## 21 Salem St - Permit #1416

Tracie Reed <traciereed@dextrouscreative.com>  
To: Christina Stacey <cstacey@portlandmaine.gov>

I just took a look at this application you submitted for the above property. There are a couple questions/concerns:

**A-4.1**

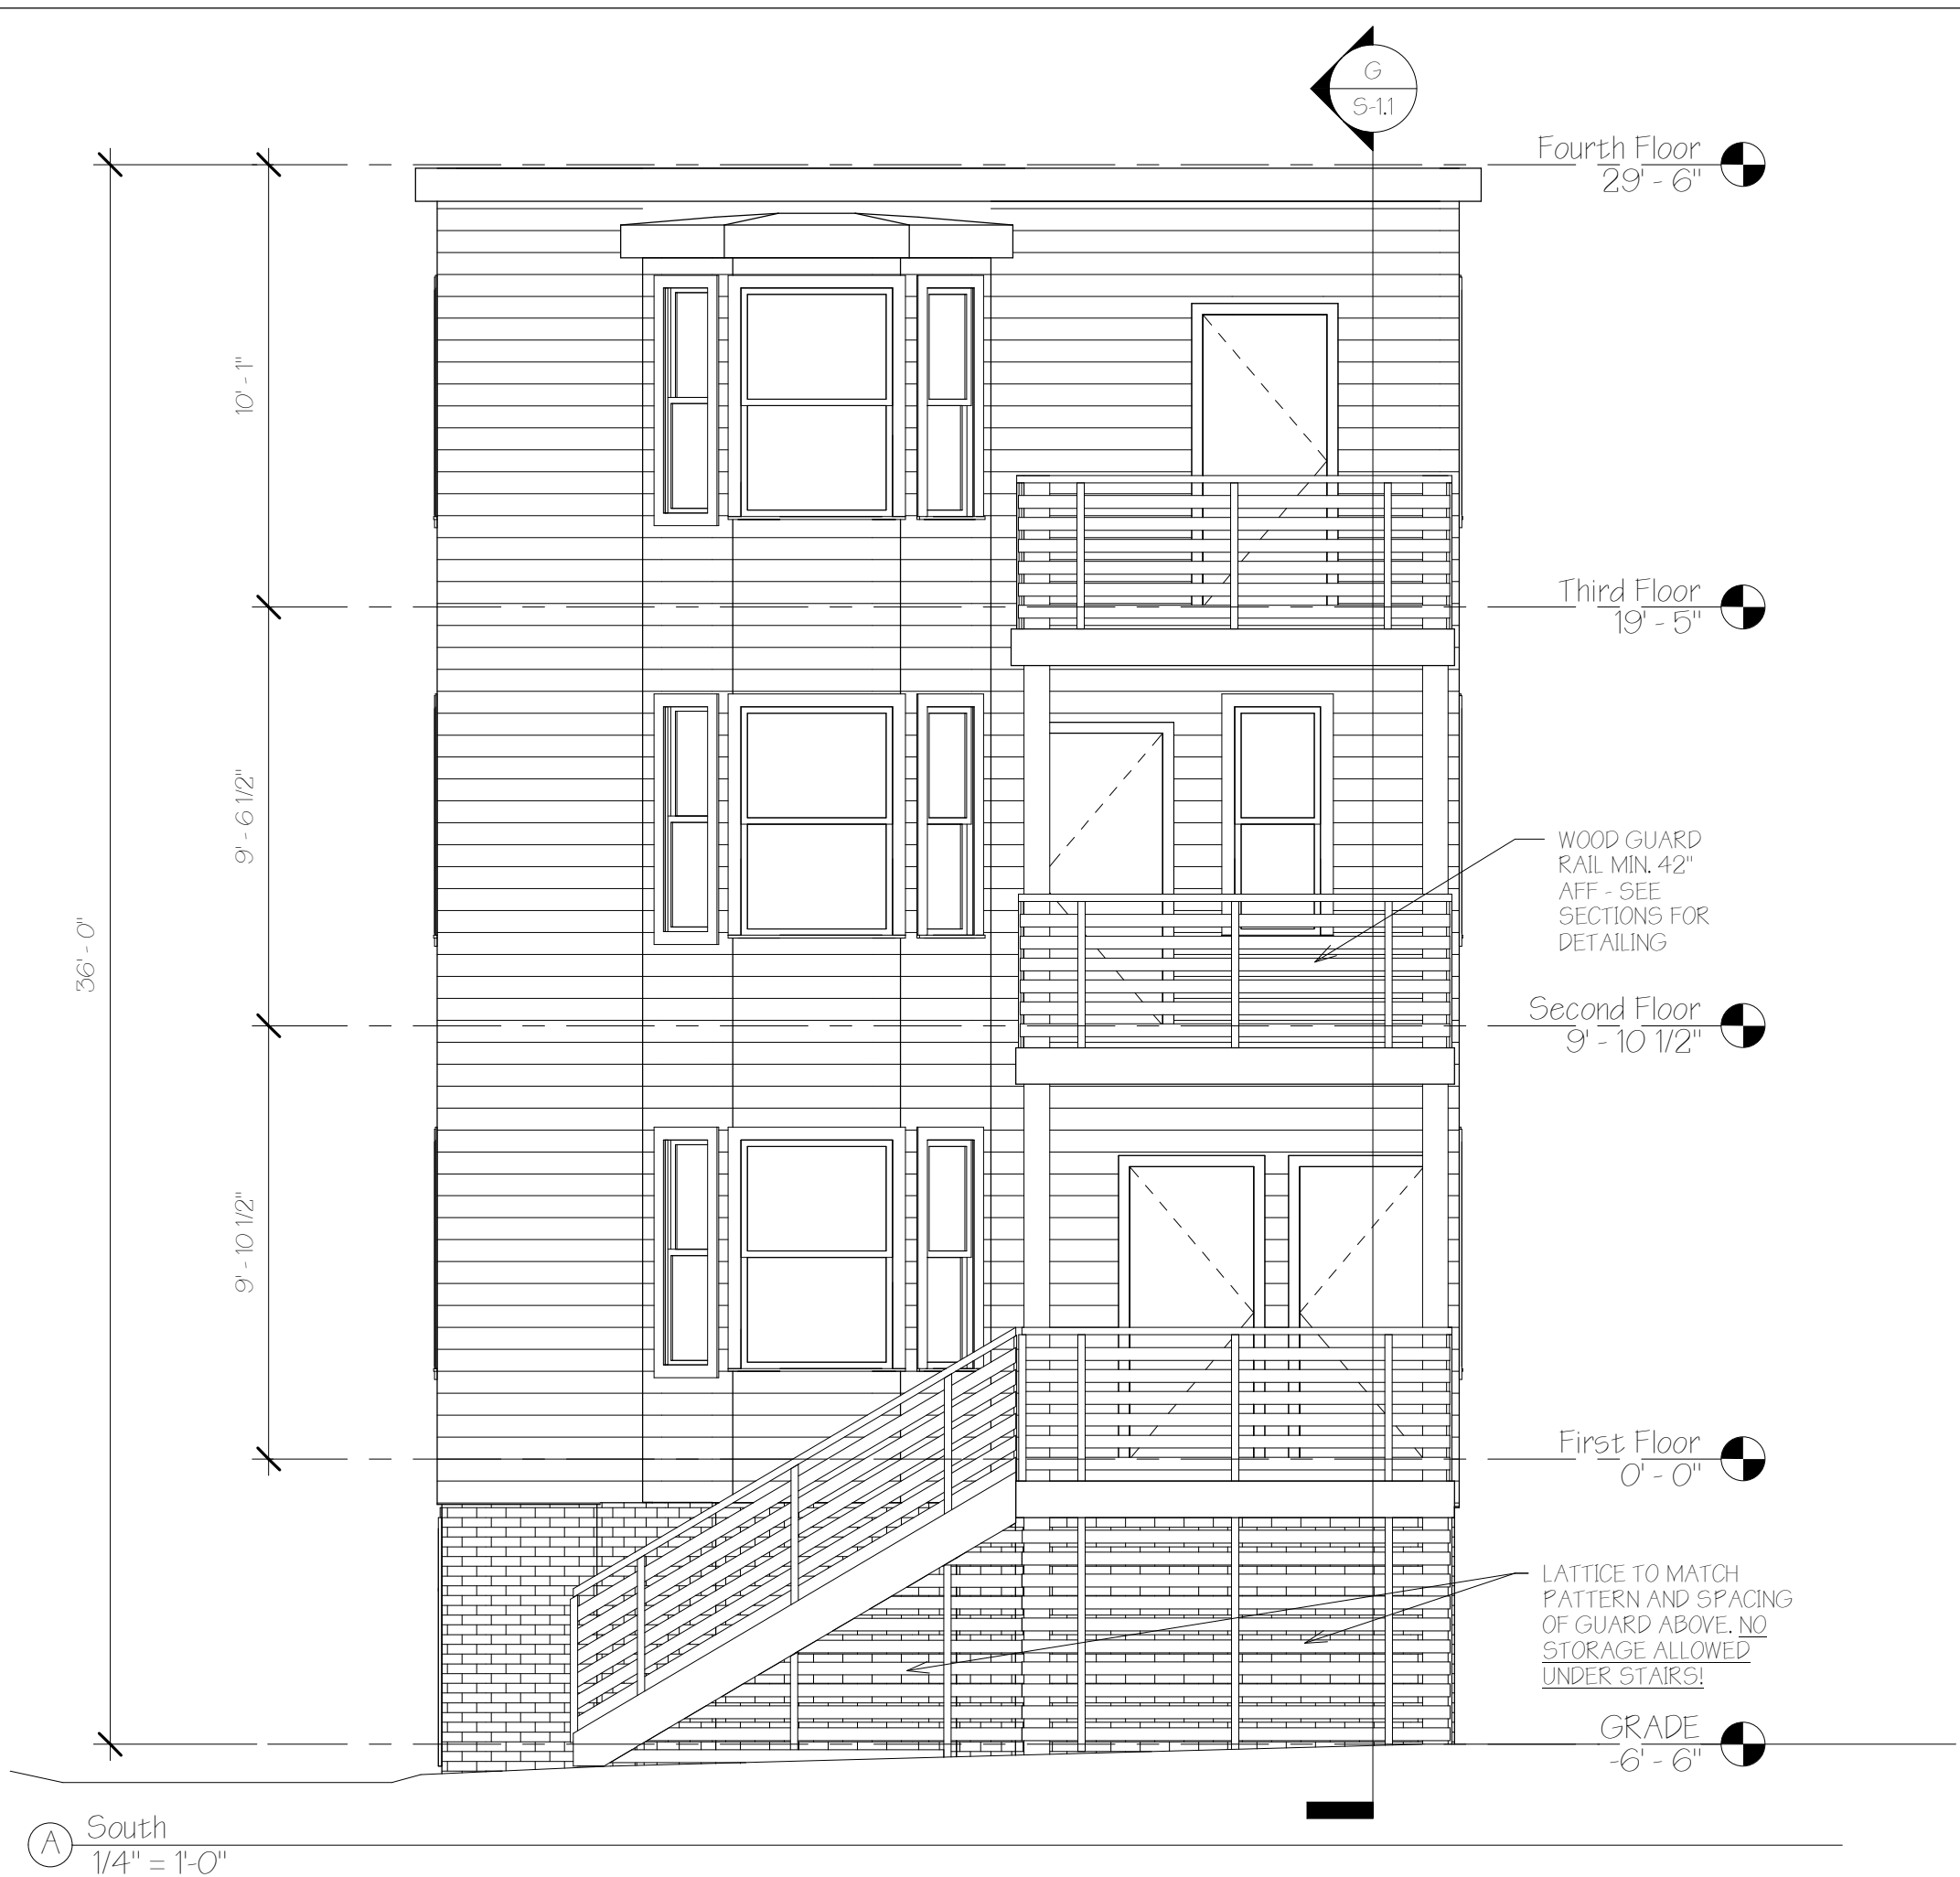
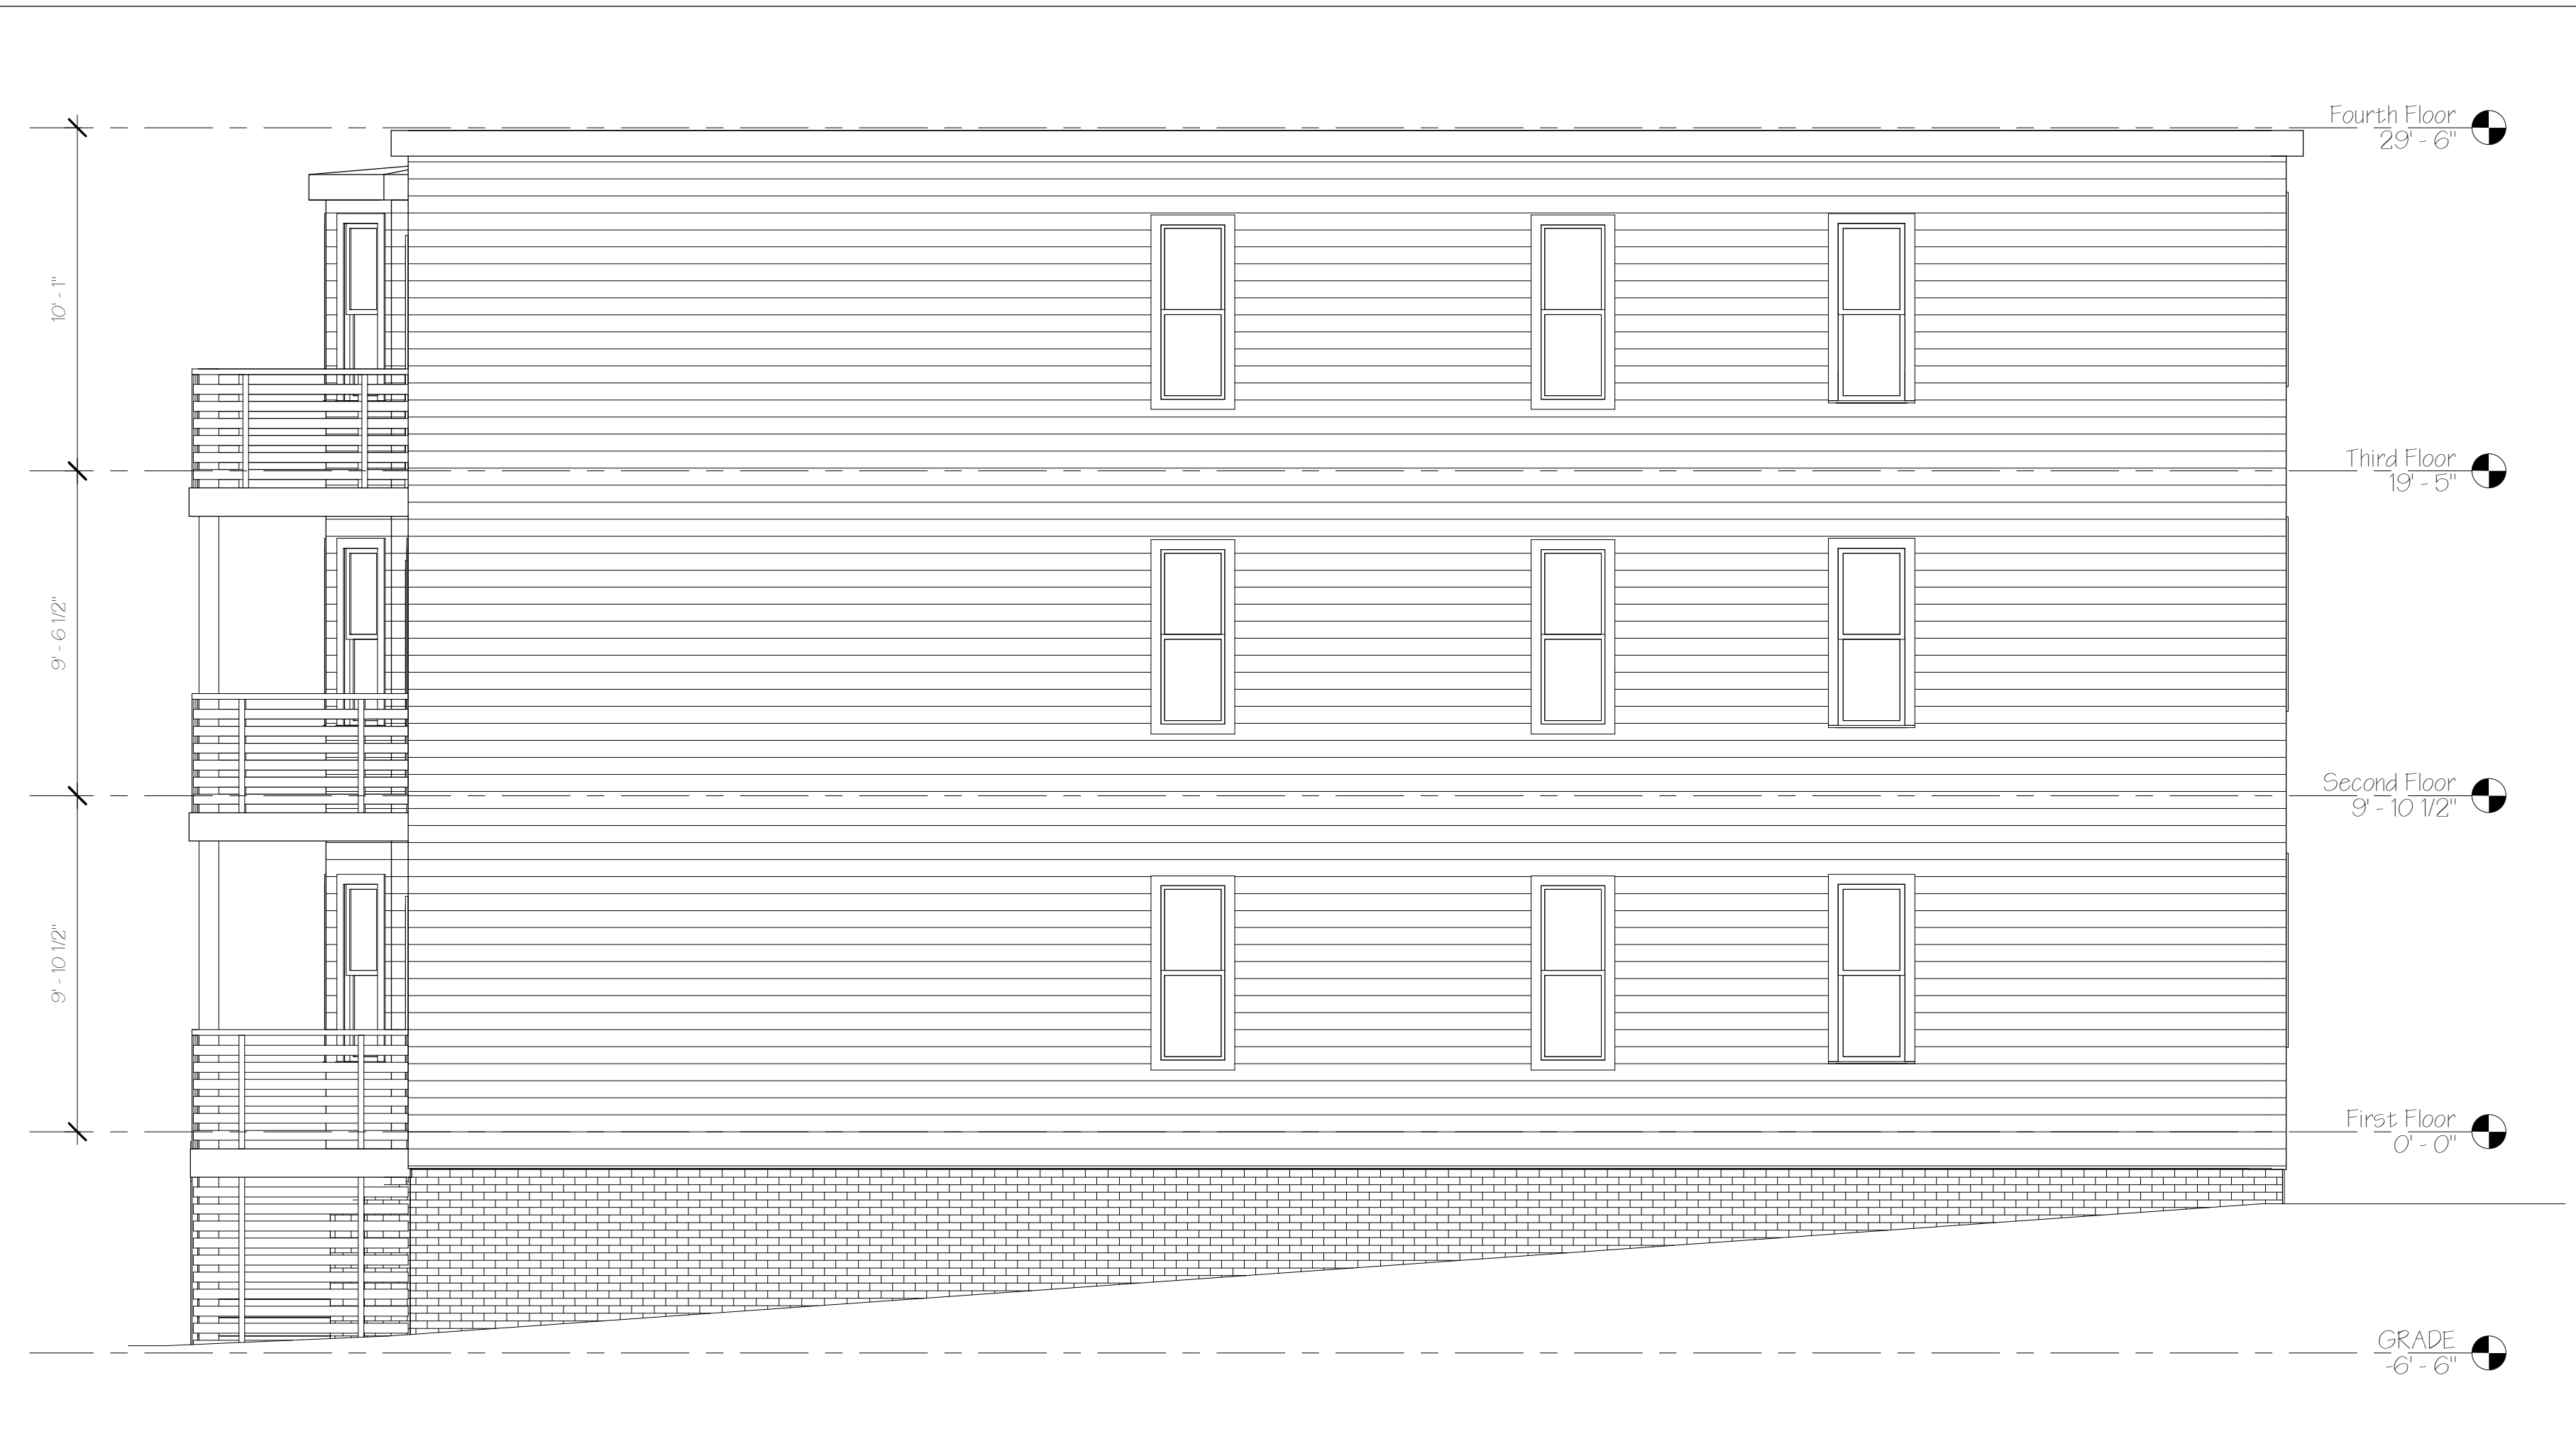
Second, the upper story balconies (particularly the third story) could present some issues for zoning. Although they are proposed to go over the footprint of the existing first floor entry, they are still considered new additions to the building and must meet setback requirements (NOTE: the second story balcony is probably actually OK since it is essentially just putting a railing around the entryway roof, which is allowed).

The front setback minimum is either 5' or the average of the setbacks of the abutting houses on either side of this house. It looks like the new balcony will be at a 0' setback. You can double check the abutters' measurements on the ground to see if your client can qualify for a lower setback using the average. If not, I think you would need to revise the plan so that the front setback of the third-story balcony is meeting whatever that average is.

Chris, Thanks for your review. At present the rise/run of the stairs do not meet current code requirements so the extension is to fulfill those requirements. In terms of the front setback you are correct that we've got a 0'-0" setback ourselves. The adjacent houses are not 0'-0" setbacks, the average may provide us a foot or so but the total depth is 6'-6" so it doesn't really seem worth it, \*ugh\* always such a tough one. Structurally and aesthetically having a tiny porch on the third porch would be very odd-looking, too.

I'll confer with my client and let you know what they'd like to do. I'm guessing there are no other exceptions to the zoning that might be helpful in terms of the third floor deck?
